Health
Infrastructure

Re: St George Emergency Department SSD 5029 – Additional Response to Submissions

Following our letter of 29 October 2012 responding to submissions received during and subsequent to exhibition of the above project, additional information is attached that provides:

7	ISSUED FOR PLANNING	08.11.12	MT
6	ISSUED FOR PLANNING	03.08.12	MT
5	ISSUED FOR PLANNING	14.04.12	MT
4	ISSUED FOR PLANNING	14.06.12	MT
3	ISSUED FOR PLANNING	12.06.12	MT
2	ISSUE FOR PLANNING	03.11.11	MT
1	ISSUE FOR INFORMATION	17.10.11	SK

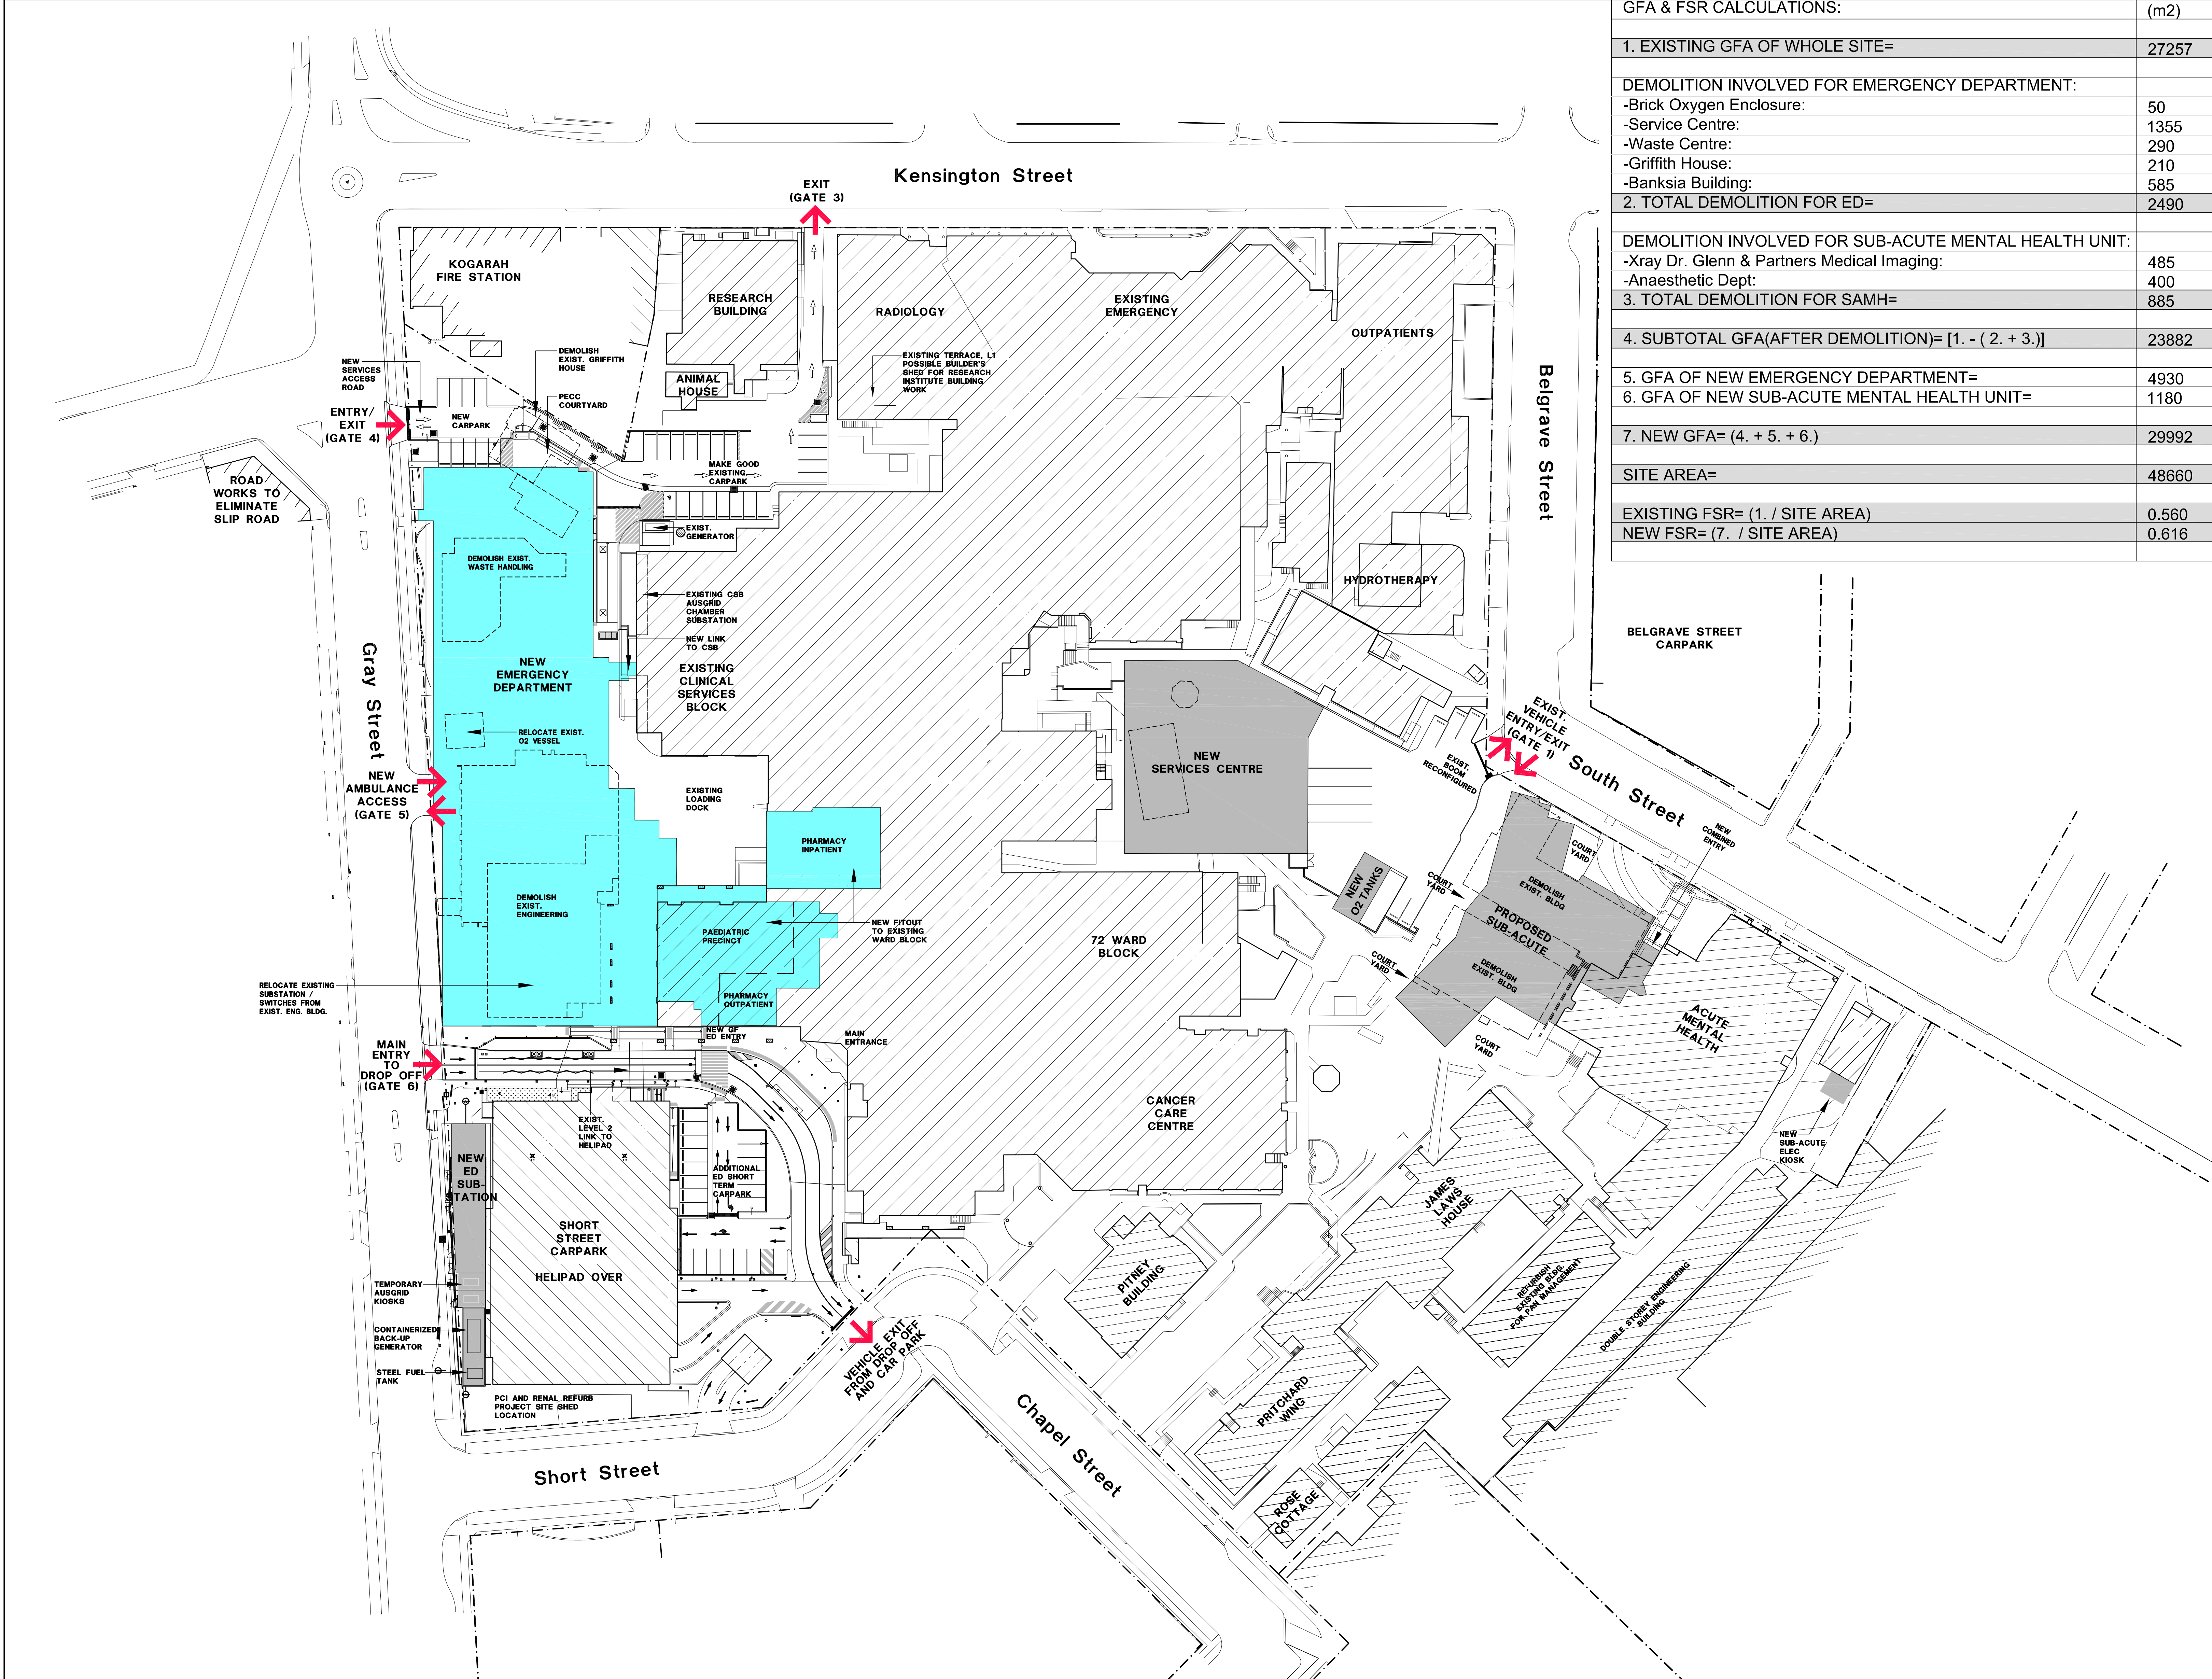
Transport for NSW provided a late submission on 25 October 2012 raising concerns in respect to the additional Gray Street drop off zone. This drop off zone was incorrectly shown on the site plans and has now been removed from the plans in accordance with the civil drawings. A Gray Street drop off is not intended to be part of the proposal. In respect to the Construction Traffic Management Plan, a draft plan was submitted with the application and will be completed as required prior to construction commencing. This plan will detail pedestrian safety and amenity.
